One Earth Solar Farm

Appendix 11.5: LVIA Consultation

February 2025

Document Reference: EN010159/APP/6.21

Drawing file: published-documents / EN010159-000304-6.20 Environmental Statement Volume 3 - Figures 11.11 Scoping Viewpoint Locations.pdf

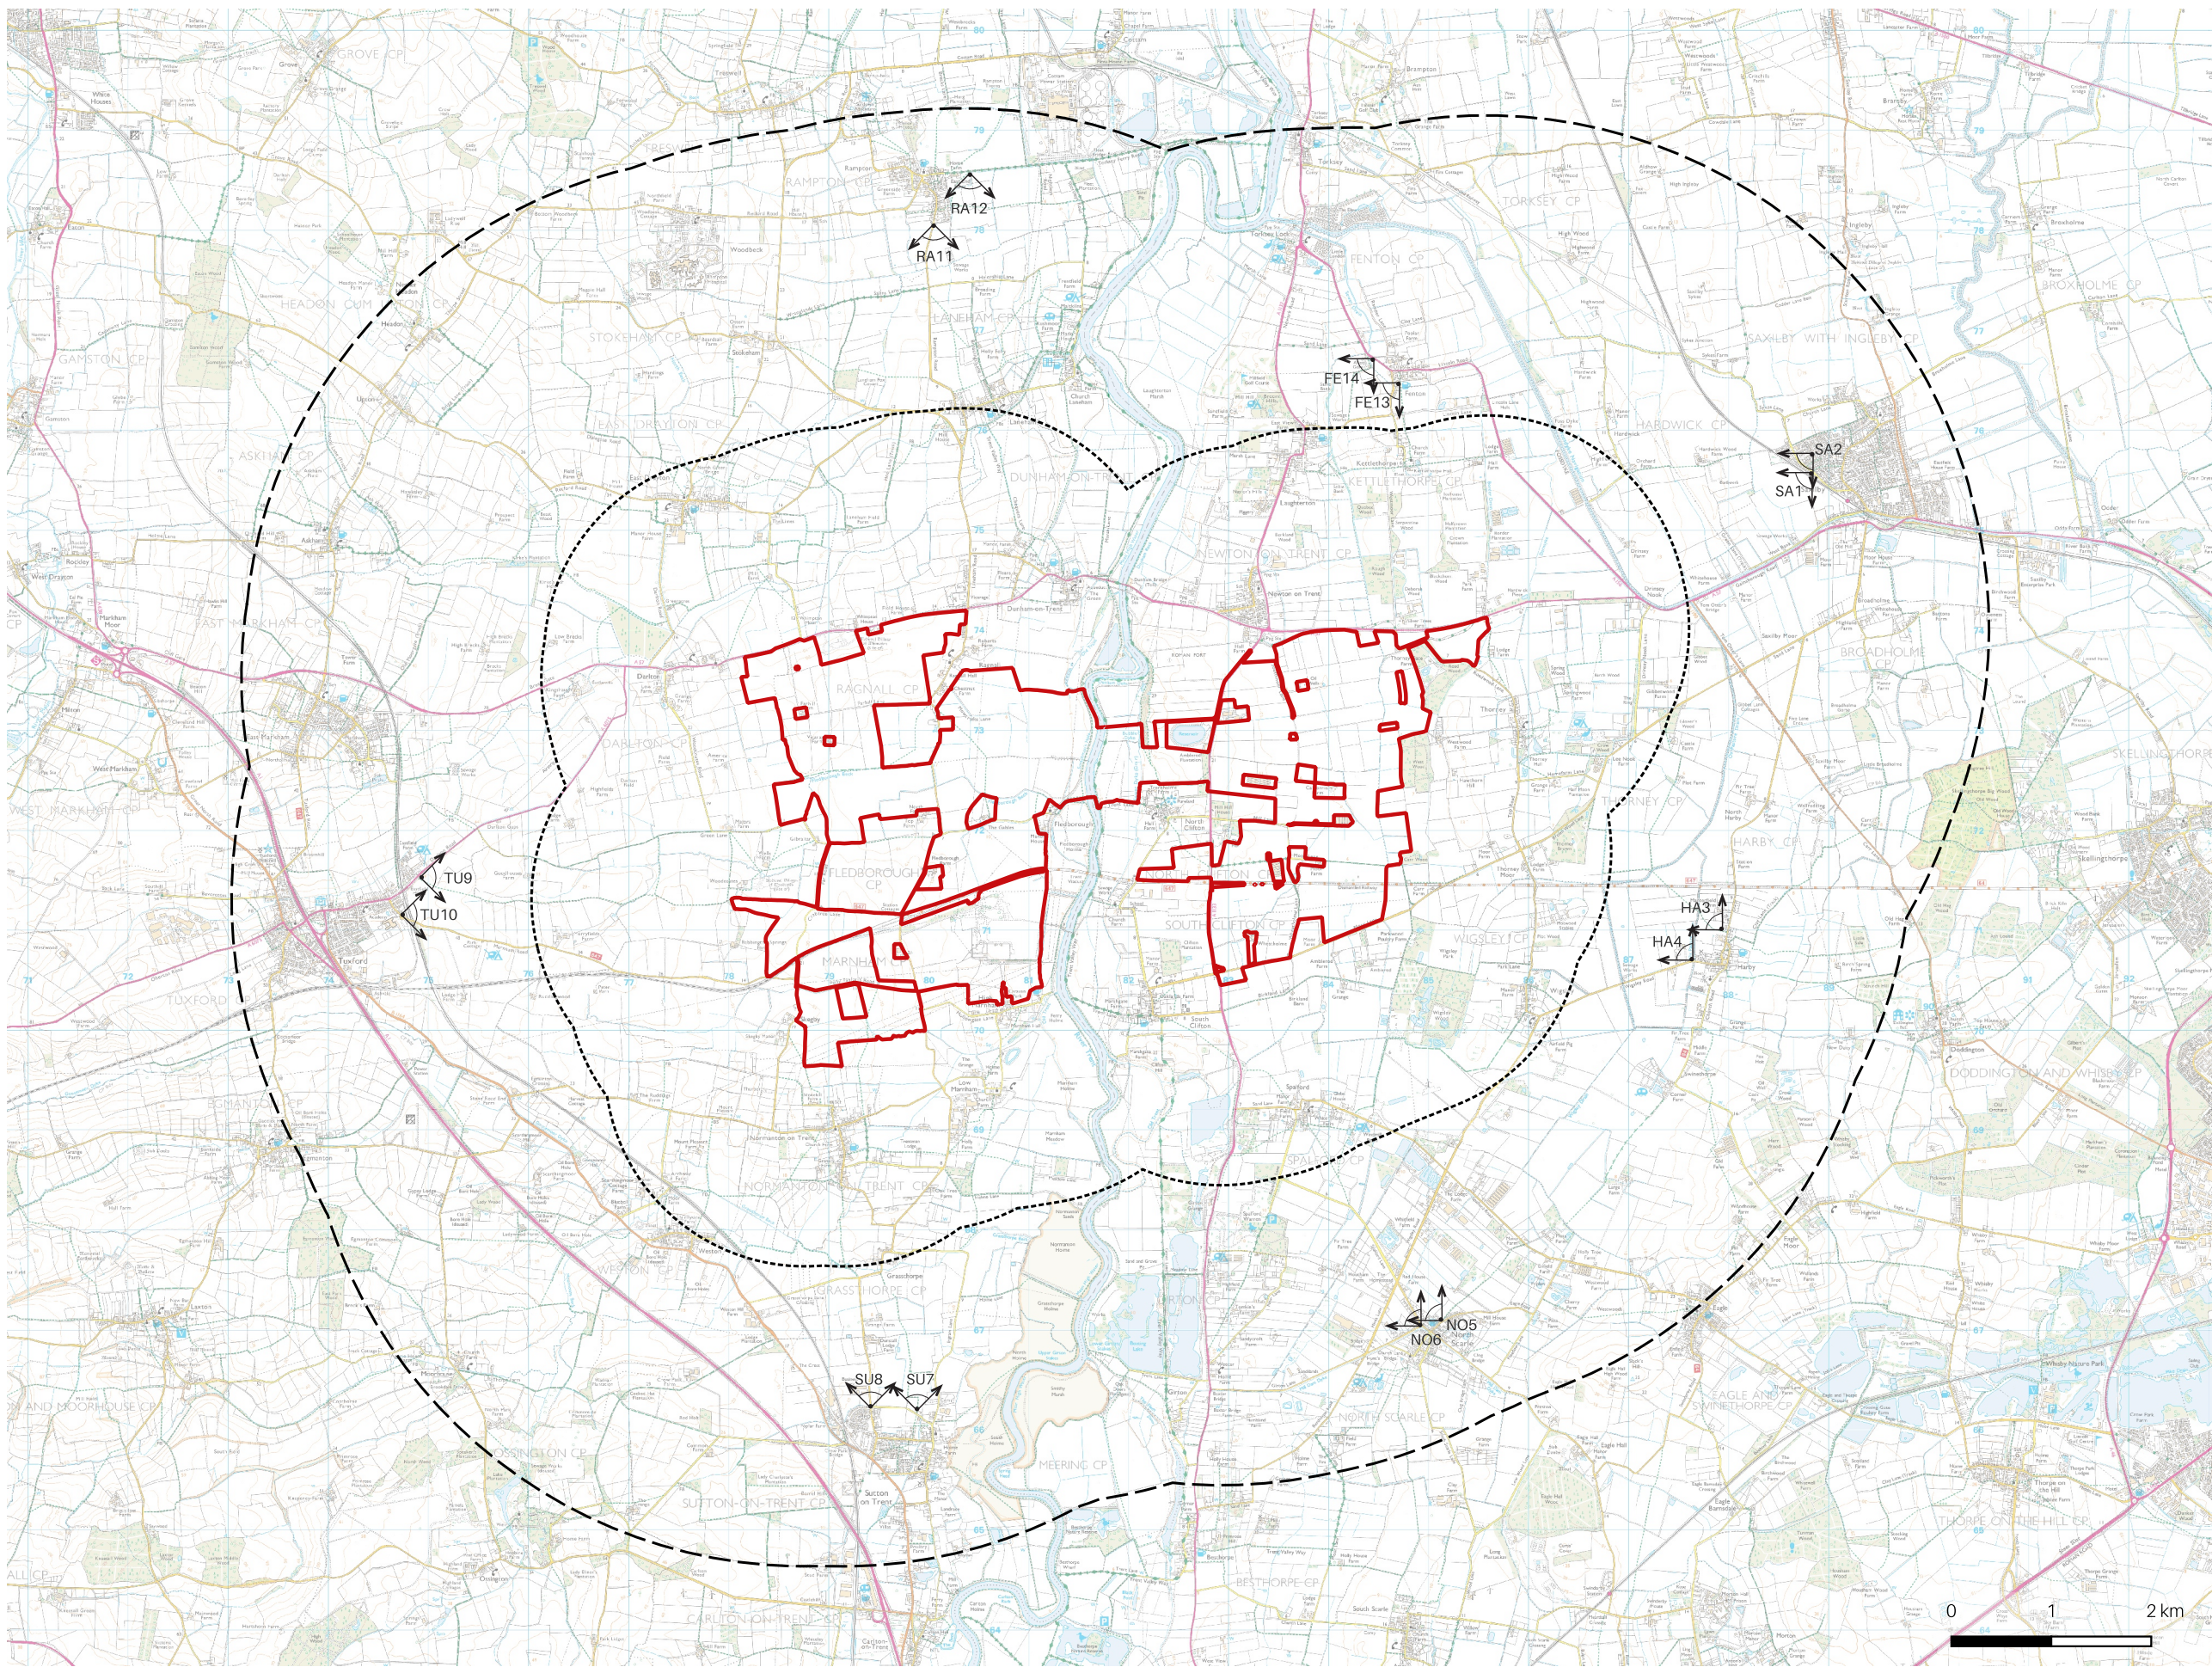
| Item for discussion / agreement | Record of discussion | Action / agreement |
|---|---|---|
| LVIA study area | Discussion was had around the additional material that was previously circulated by Icen Projects to support a 2km Study Area including scoping photos and associated location plan. | It was agreed a 2km Study Area was appropriate, but it was requested that the detailed justification was included within the LVIA for the benefit of the Inspector. This is now provided at Appendix 2 of this summary note. |

- Requirement to quantify the scale of permanent landscape change for substation sites when greater certainty of impacts can be given.
- Recommendation to provide further justification for the LVIA study area with the scoping process clearly evidenced
